Planning Application for 75 Dwellings at Bonhams Field, Main Road Yapton ADC ref. Y/98/20/PL

Response to Parish Council Comments

Image showing approved layout plan

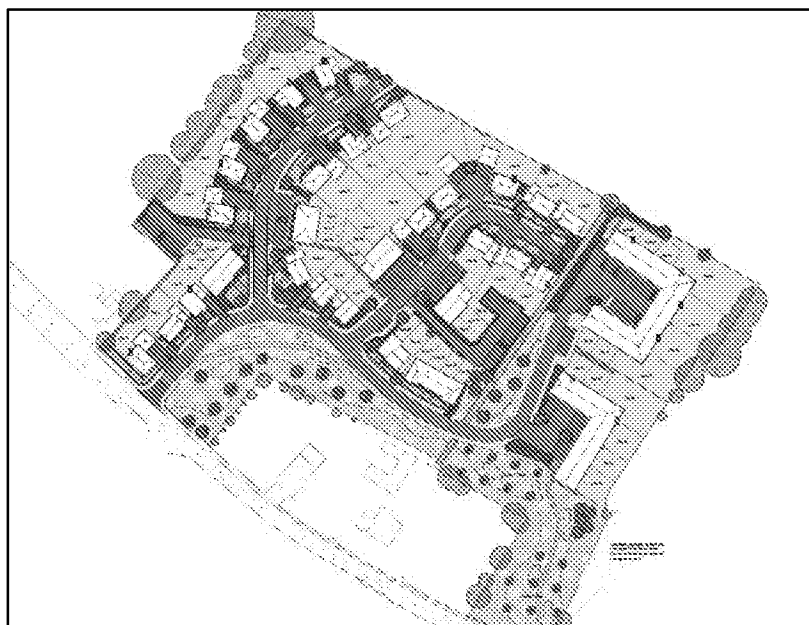
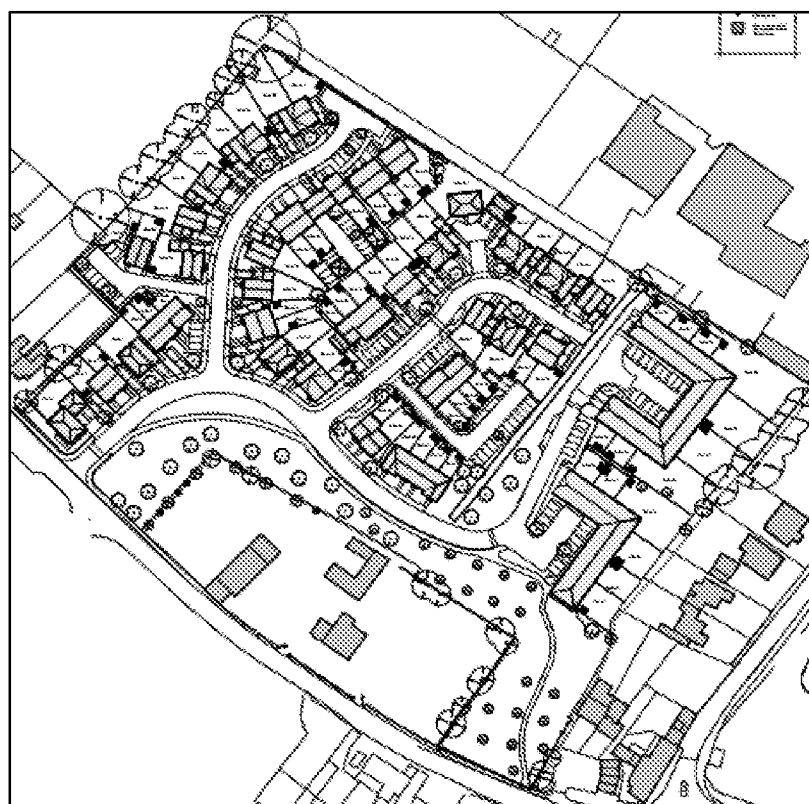
The layout reflects that of the consented scheme which YPC expressed deep concerns regarding the impact of the scheme on sight-lines both into and out of the site on the adjoining conservation area and listed buildings.

It would seem that the applicant has not used this new proposal as an opportunity to reflect YPC's comments but merely as an opportunity to cram additional housing into the north east corner of the site.

YPC also note that the applicant still has disregarded the importance of the siting of units within the proximity of listed buildings Bonhams Barn and Bonhams. YPC would seek to see a proposal that respects the sensitivity of these two buildings in terms of high and proximity.

RESPONSE: There is no significant change to the layout, scale or general appearance of the dwellings adjacent to the Conservation Area or setting of the closest listed buildings.
